DEVELOPMENT REVIEW BOARD
SUPPLEMENTAL SUBMITTAL

PROJECT NO. 2018-001579
Application No. SI-2020-01477

SUBMITTAL DESCRIPTION: Departmental comments indicated a number of items to be addressed in a deferred hearing date, indicated above for multi-family apartments project at 7500 Indian School Rd in the Winrock Town Center. Responses to the comments and revised sheets are provided.

This letter outlines the modifications that have been made to the Apartments at Pennsylvania St and Indian School Rd application for a major site plan amendment to the approved Winrock Town Center Site Development Plan (PR-2018-001579) to address the agency comments that were received.

SHEET NO. SDP1.1 OF

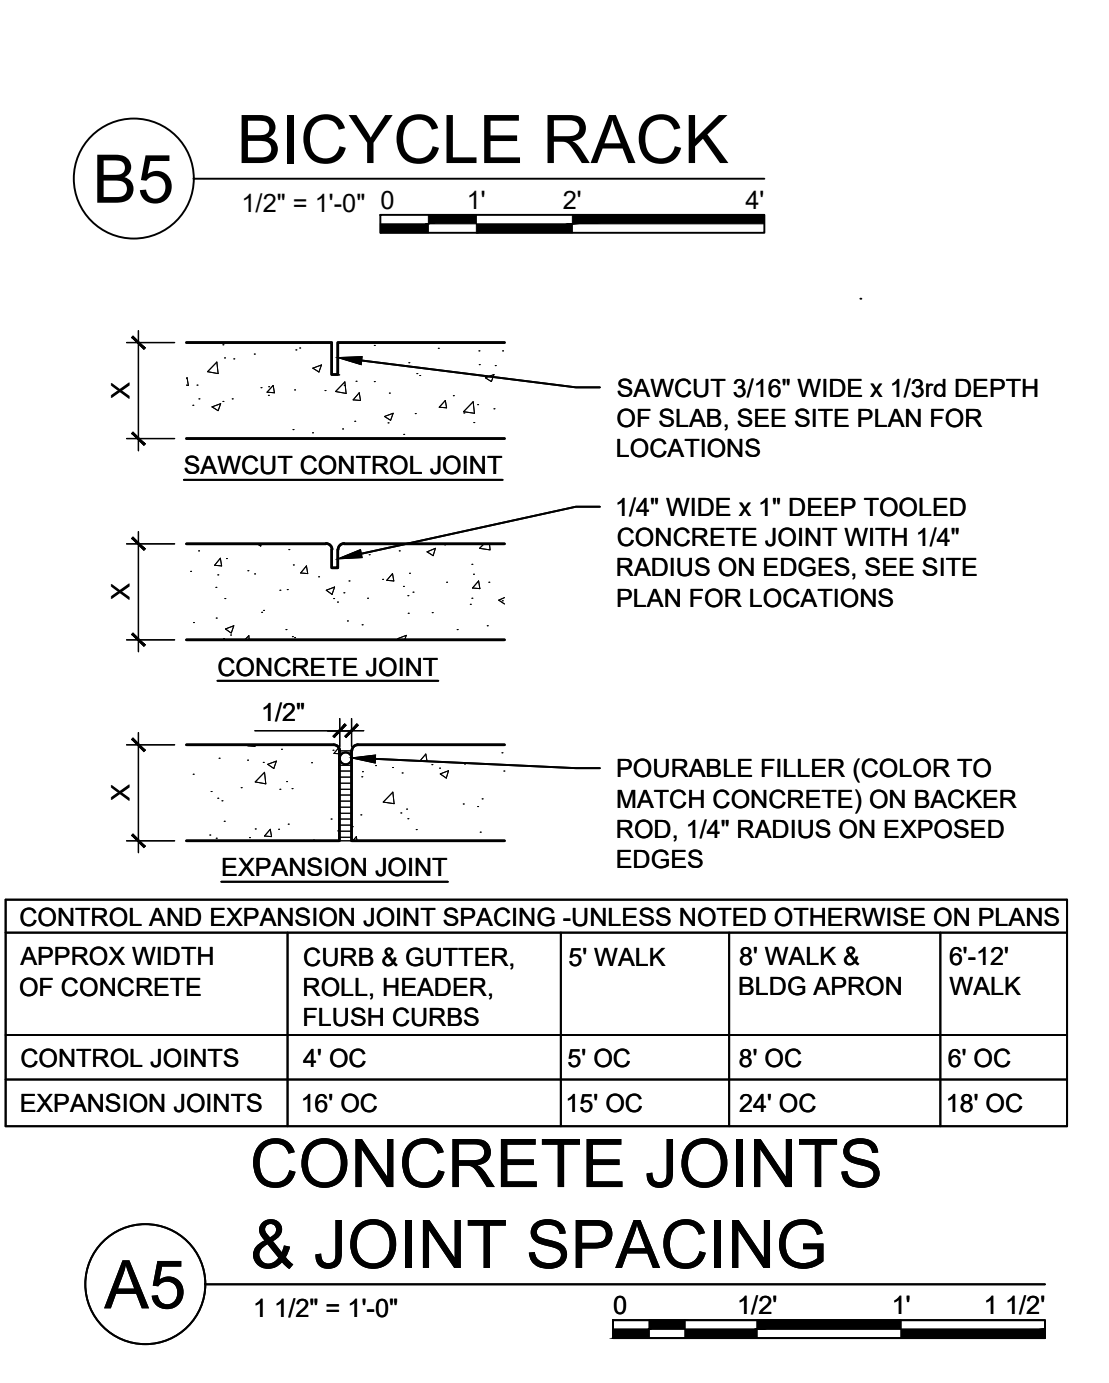
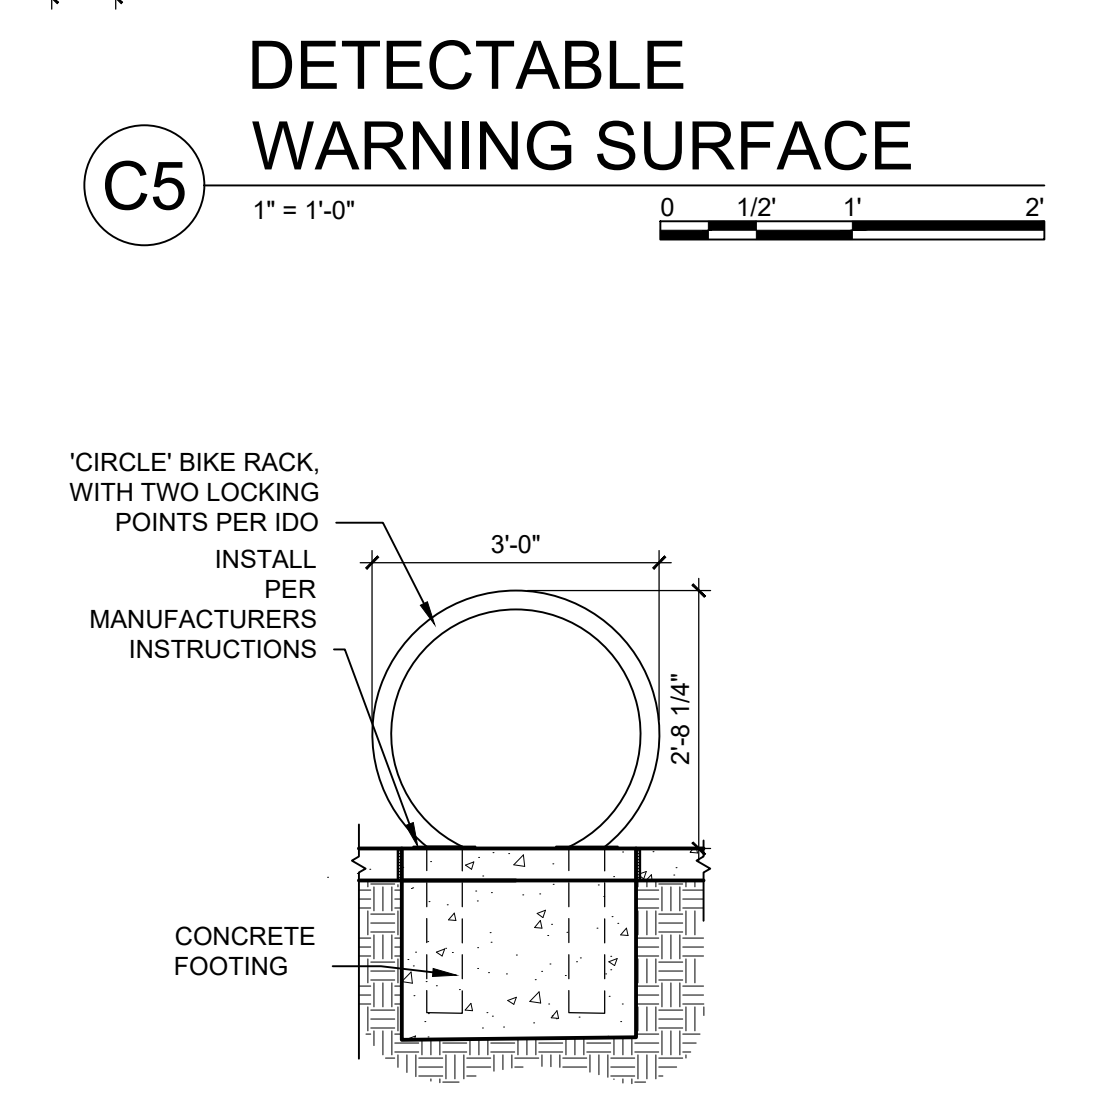
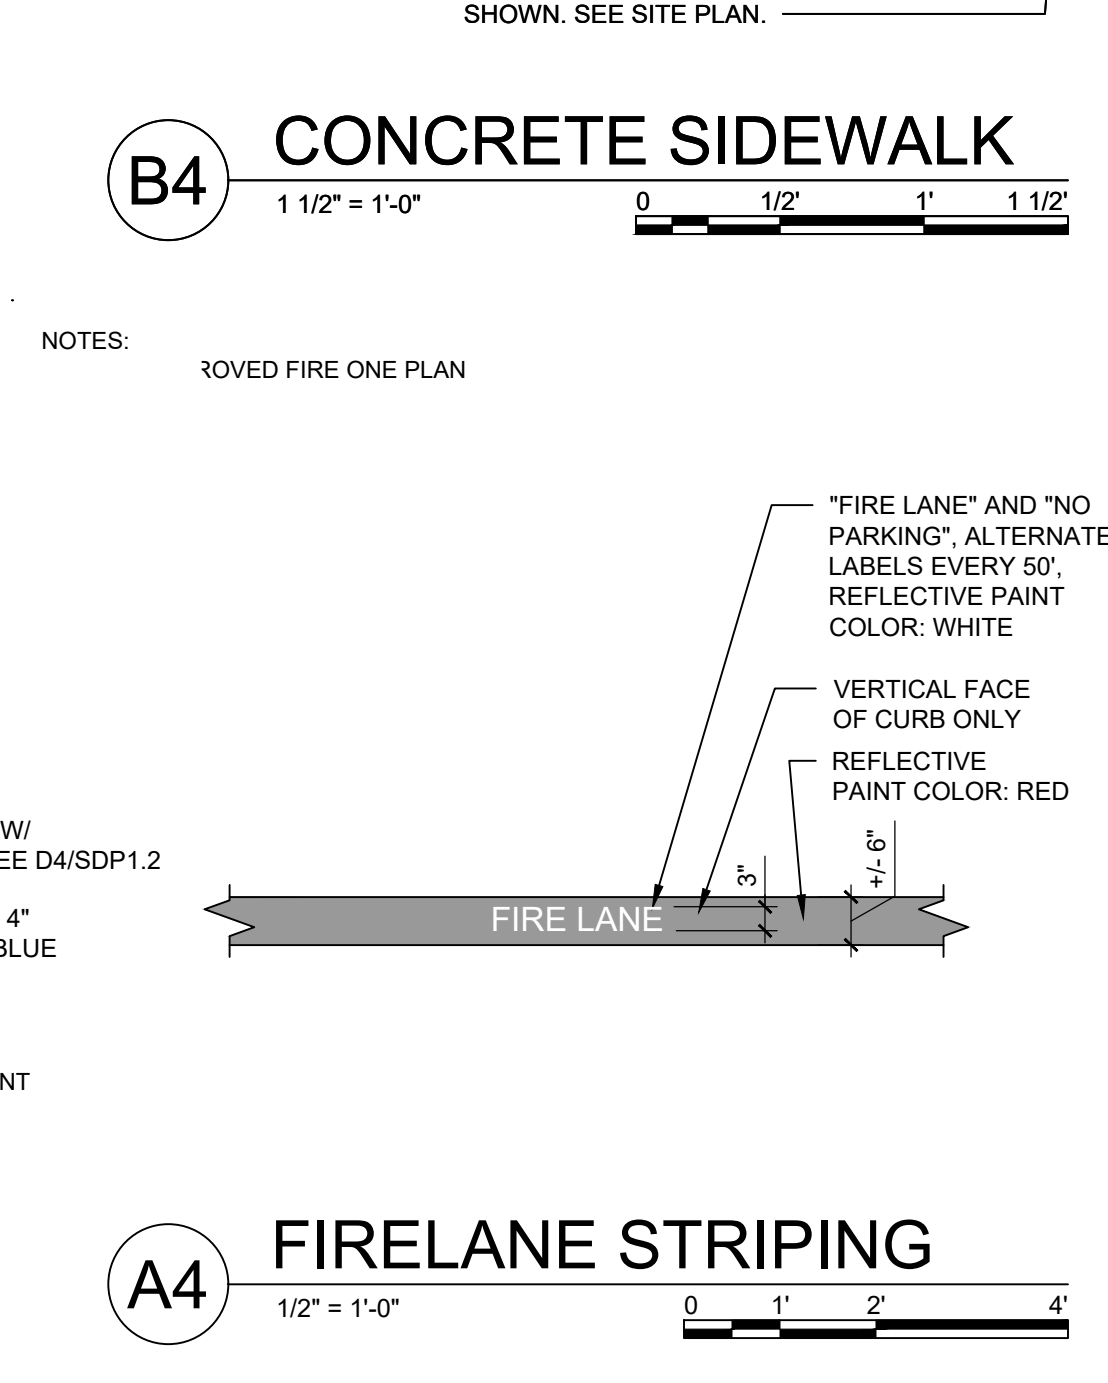
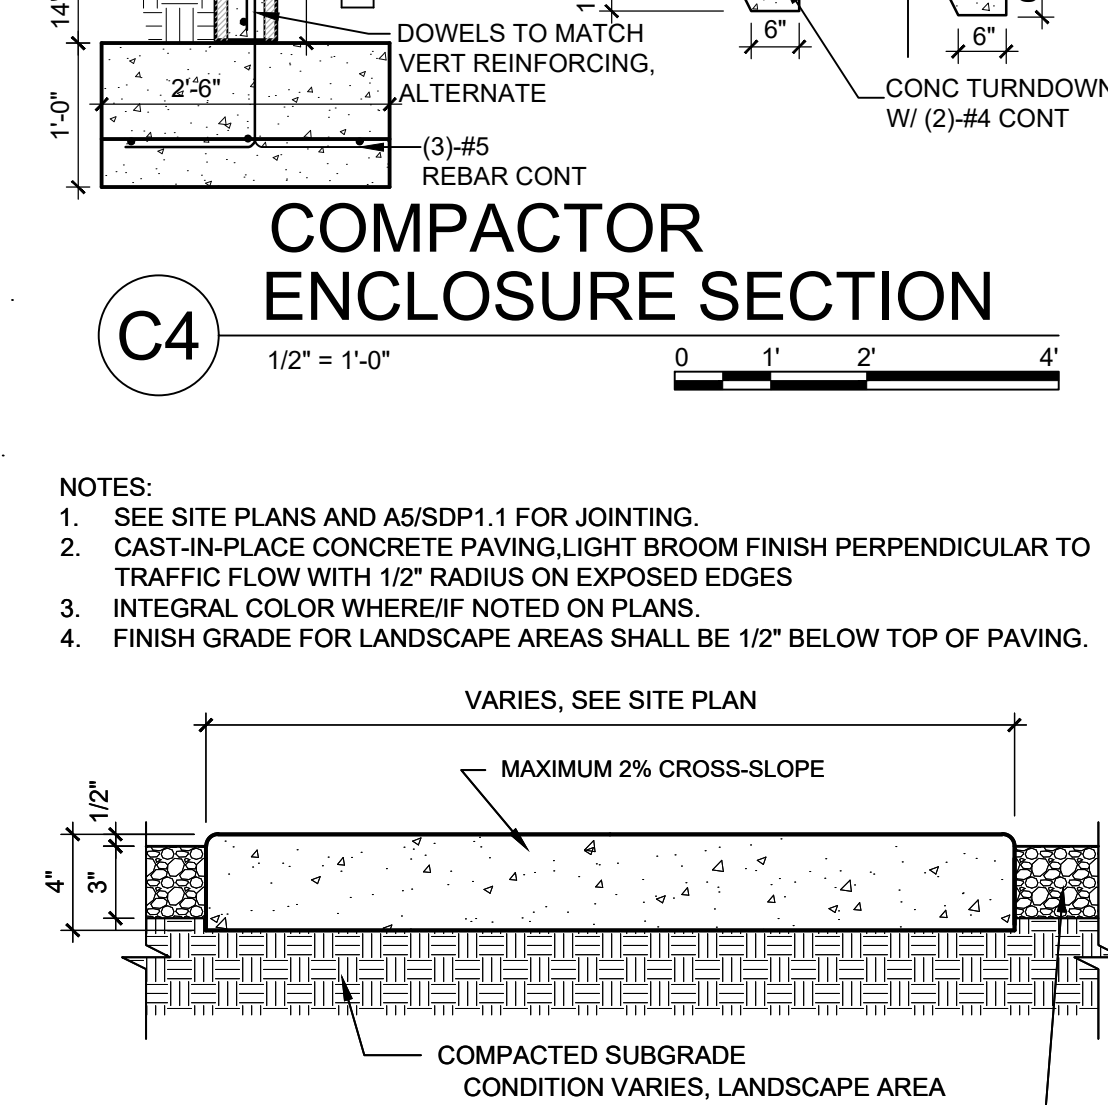
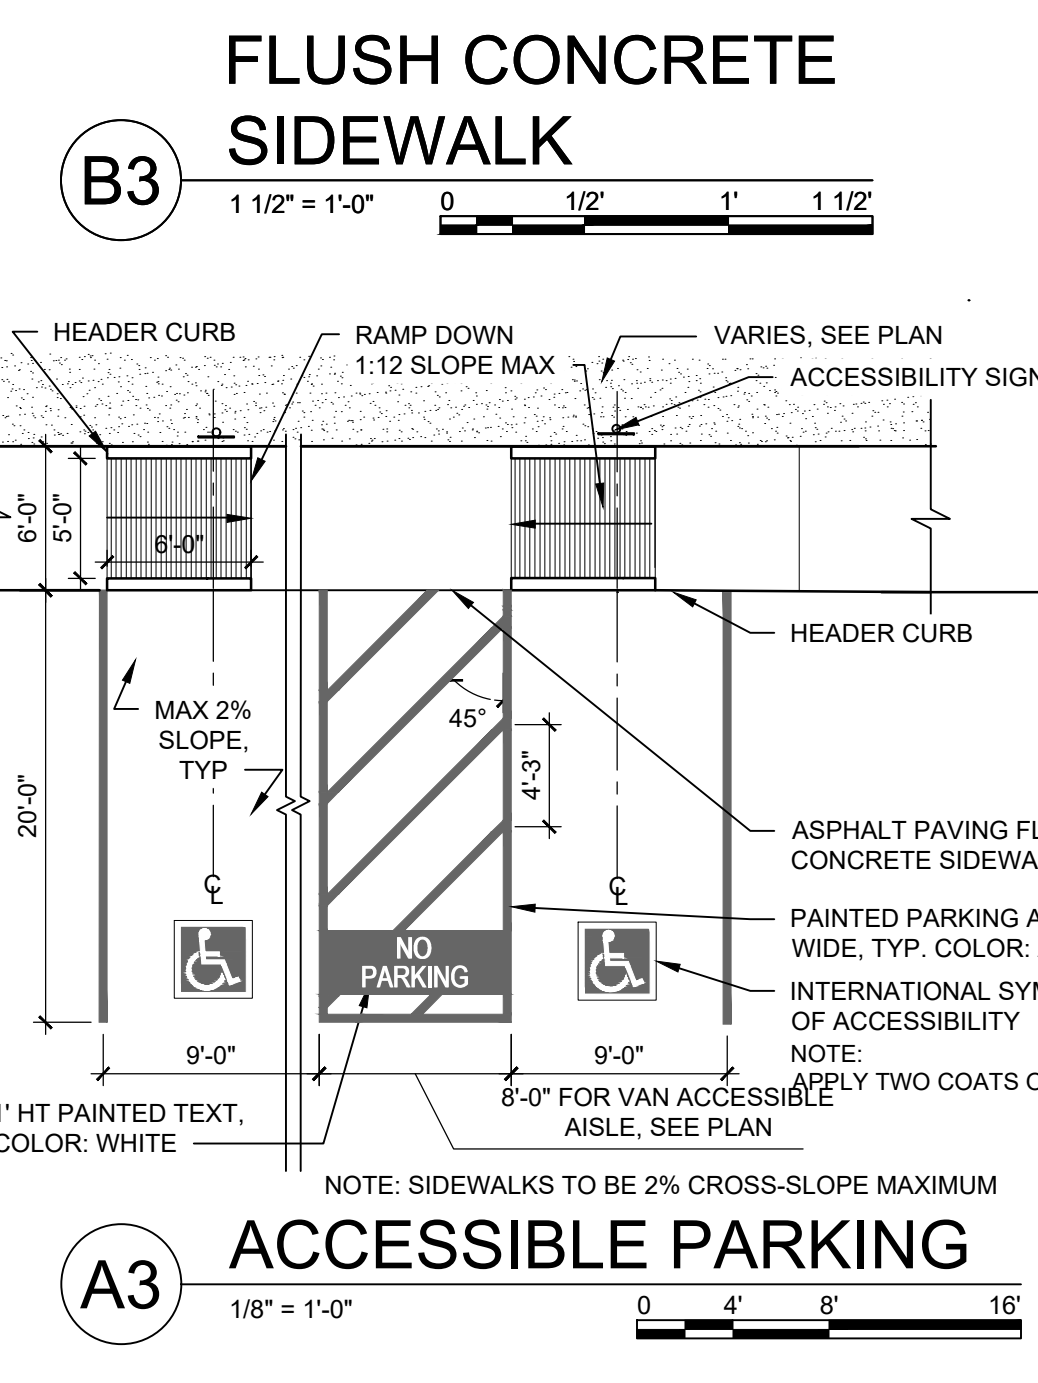
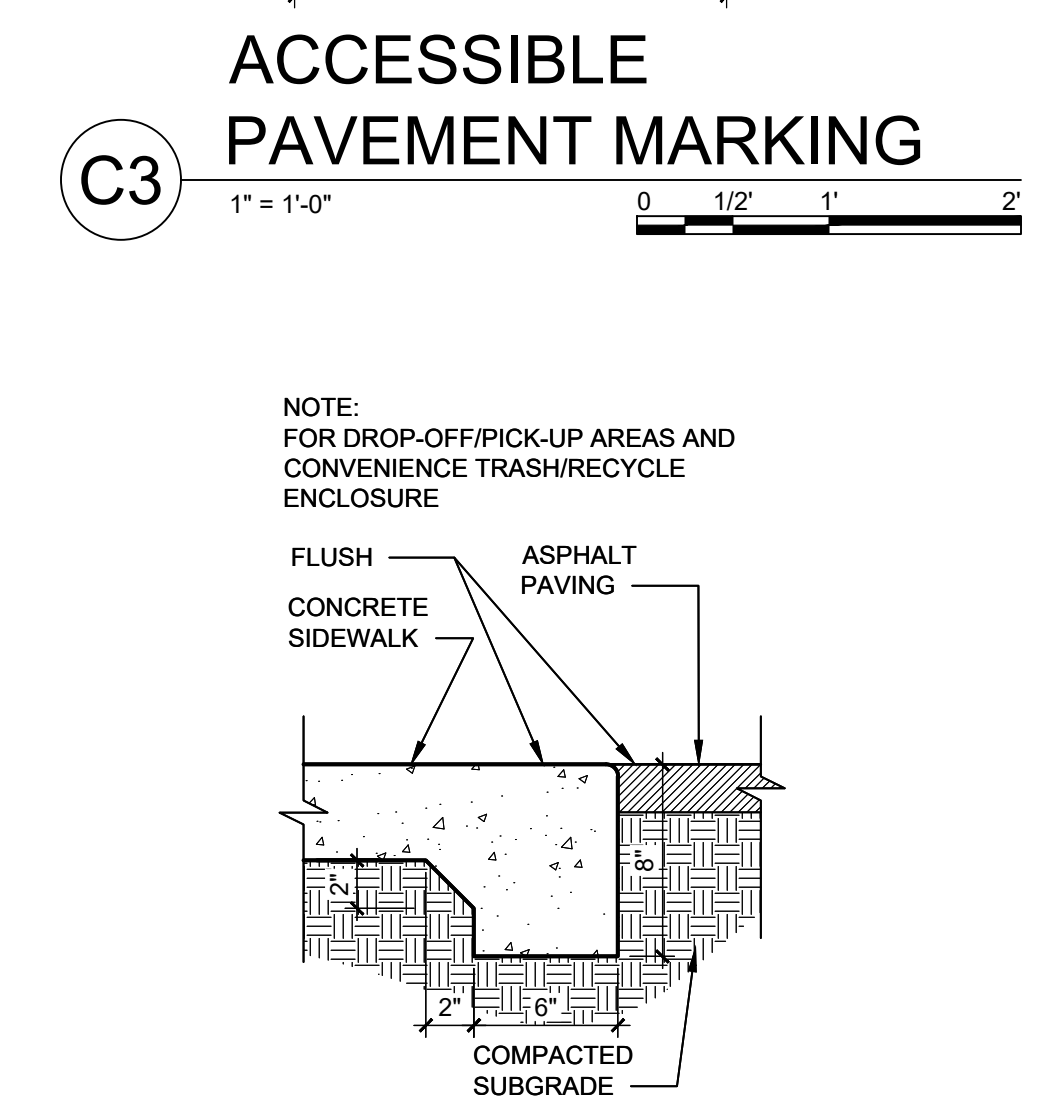
3. For a road exiting onto Indian School Road, use a yellow double stripe for separating opposing directions of traffic and use a single white stripe for separating traffic lanes that are traveling in the same direction. Pavement arrows are white as well.

4. Include "Yield to Pedestrians" signage for the wide crosswalk.

- i. Please provide documentation that the ABCWUA will have ability to access the gates (key note 28 and 30) for maintenance.

A Yellow double stripe from Indian School to raised crosswalk has been added. Pavement arrows are white.

Site signage is added to raised crosswalk and is labeled by a keyed note 39.

Access will be provided to the Fire Department, ABCWUA, and Solid Waste via job access/keyed entry. Gate at Pennsylvania (keyed note 30 on SDP 1.1) is an emergency exit only gate. Language has been added to site plan and utility plan.
